DECISION DELEGATED TO HEAD OF PLANNING

Application No: H11-0860-24 **Applicant:** Nationwide Produce PLC

Proposal: Details of external materials, scheme of landscaping and tree planting, acoustic fencing and earth bund (Conditions 4, 5, 8 and 9 of H11-1084-23)

Location: Cowpers Gate (South) Station Road Long Sutton

Drawing
Boundary Treatments (Acoustic Fencing)

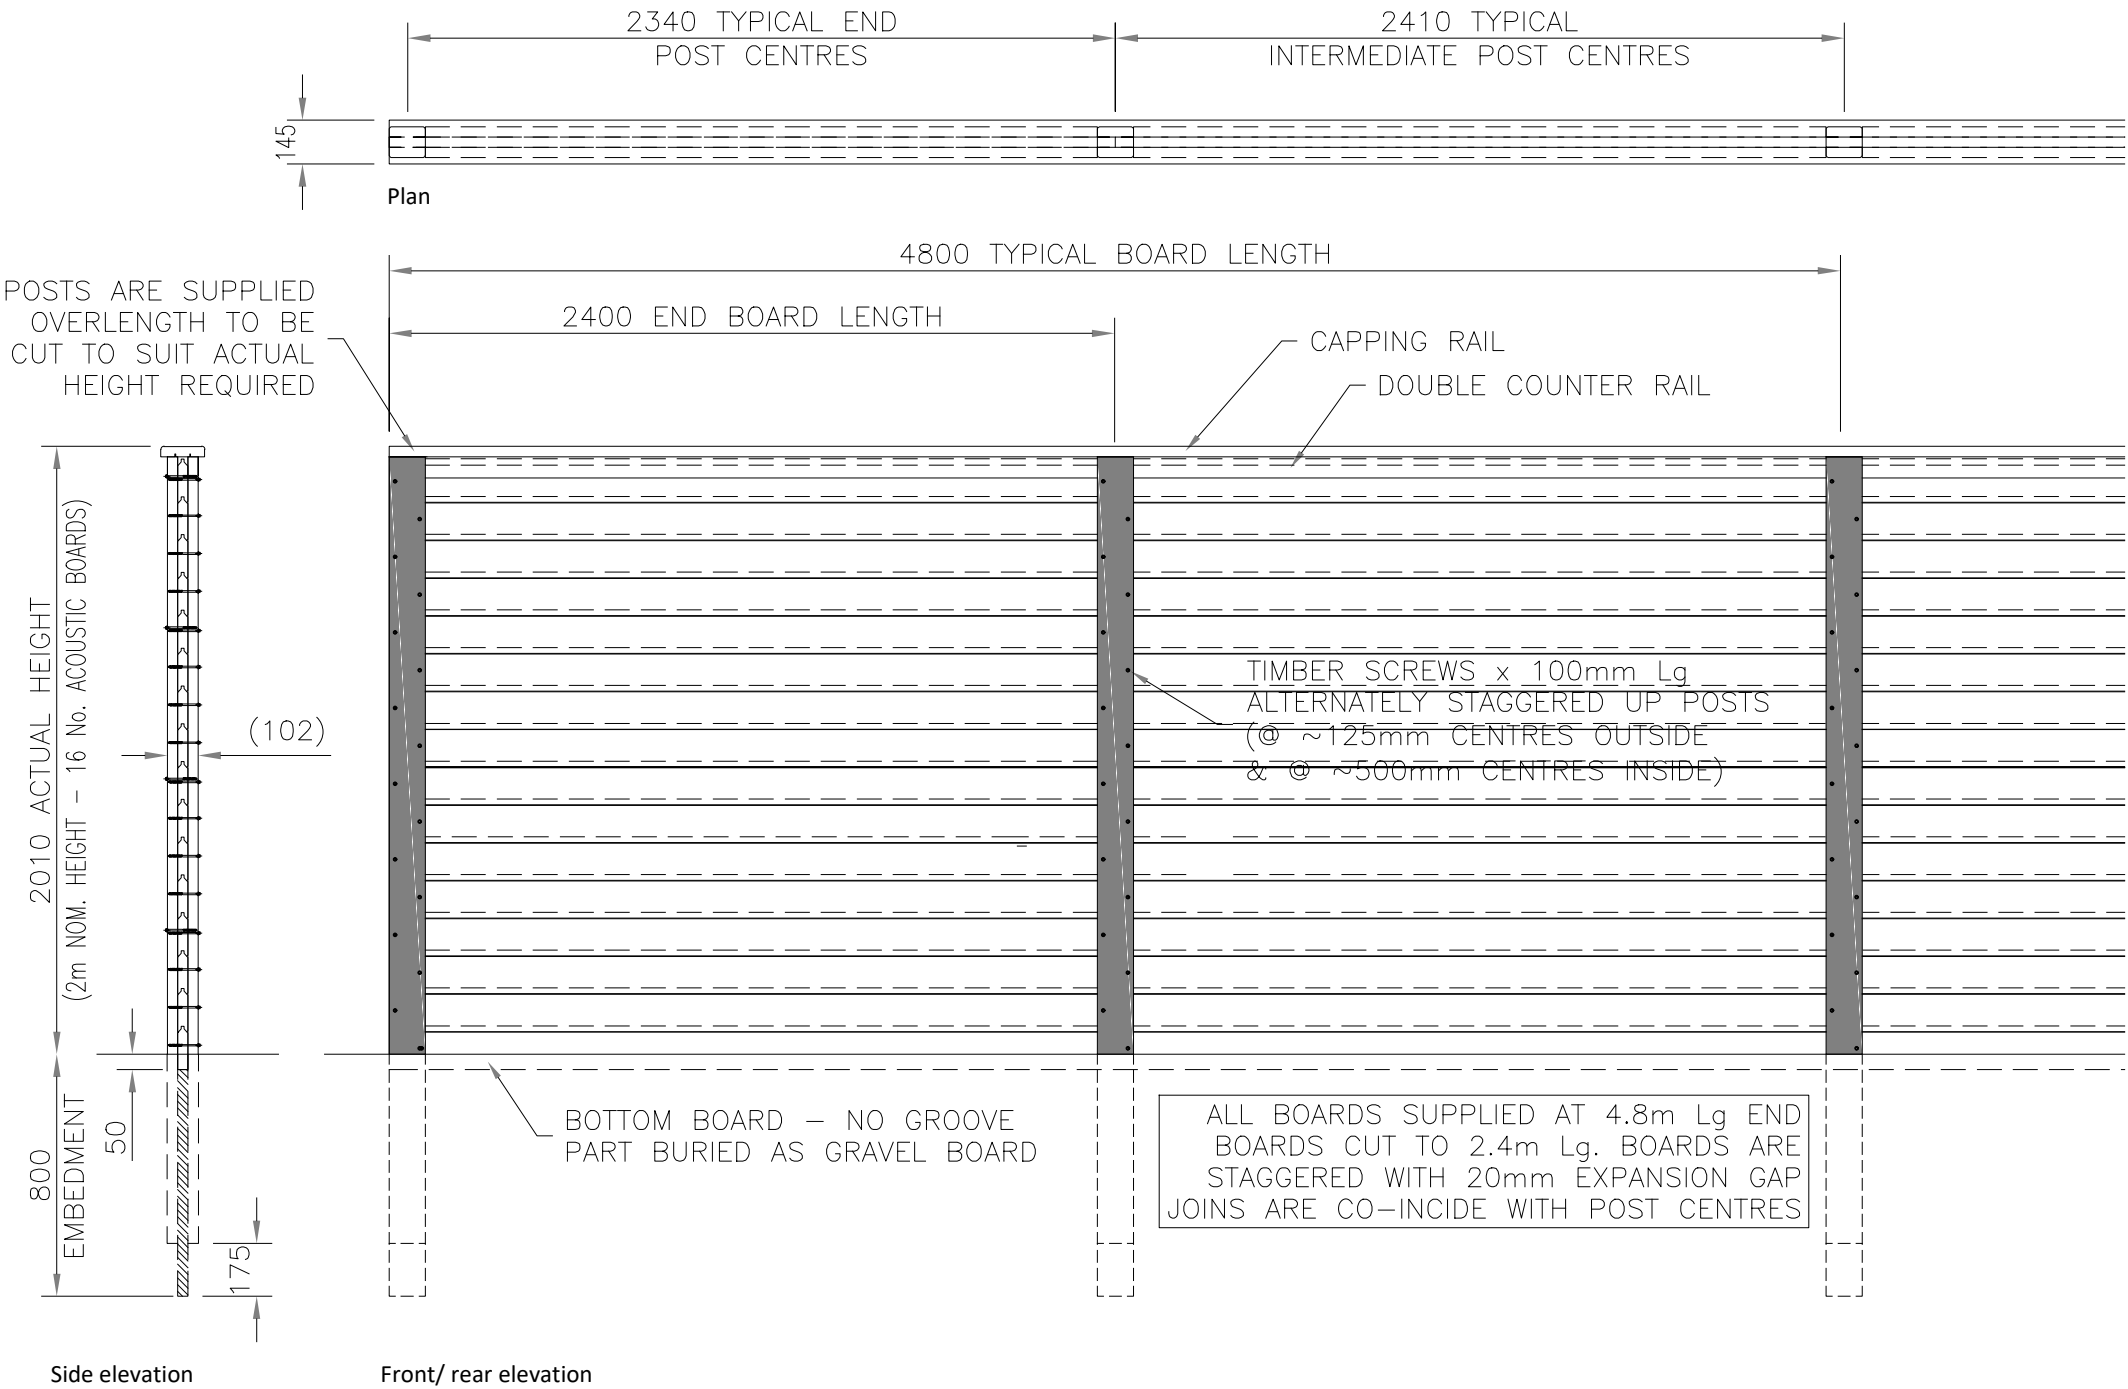
The acoustic fencing will be 2.10m tall and will be located along the northern boundary and the western boundary. South Holland District Council Environmental Protection has assessed the proposed fencing and have raised no objection confirming the proposed measures for the acoustic fence and bund are acceptable.

The details submitted with regard to the proposed acoustic fencing, are all considered to be acceptable therefore condition 8 can be discharged.
